From: Brian Elstone [REDACTED]
Sent: 08 June 2026 09:08
To: Silvie Steiningerova <Silvie.Steiningerova@arun.gov.uk>
Subject: RE: LU/90/26/HH- 2 Old Warehouse Mews

From: Silvie Steiningerova <Silvie.Steiningerova@arun.gov.uk>
Sent: 08 June 2026 08:56
To: Brian Elstone [REDACTED]
Subject: LU/90/26/HH- 2 Old Warehouse Mews

PROPOSED PVC WINDOWS

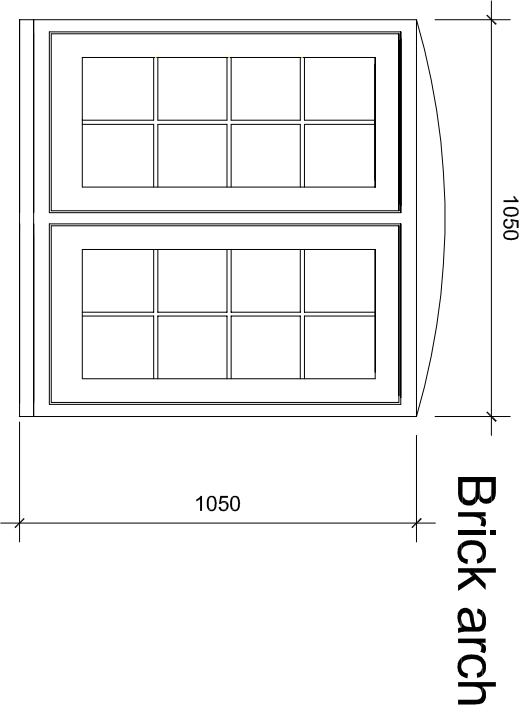
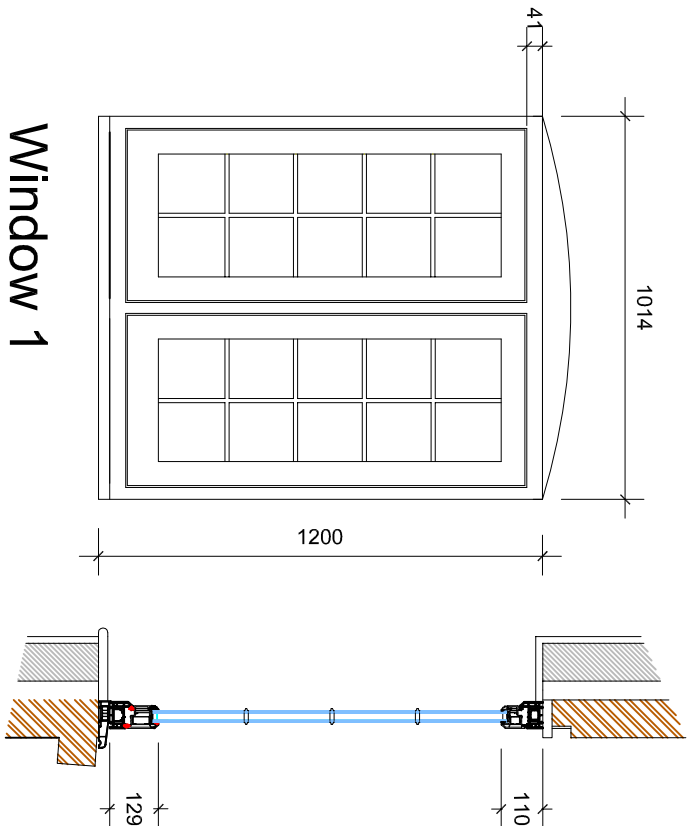
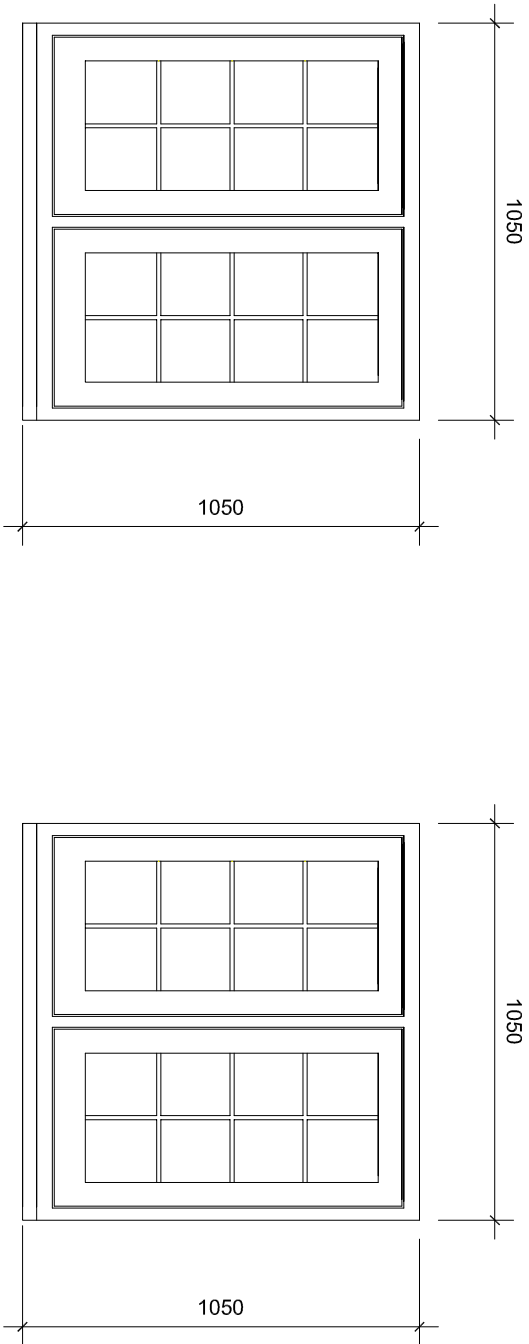
Please could you confirm the proposed thickness of the windows profile and whether the glazing bars would be integral or applied?

I have checked the spec and can confirm that the glazing bars are integral

The existing windows have frame depths which are in the order of 60mm so we shall will be using frame depth of 62mm with sash depth of 63mm which will match all the existing detail.
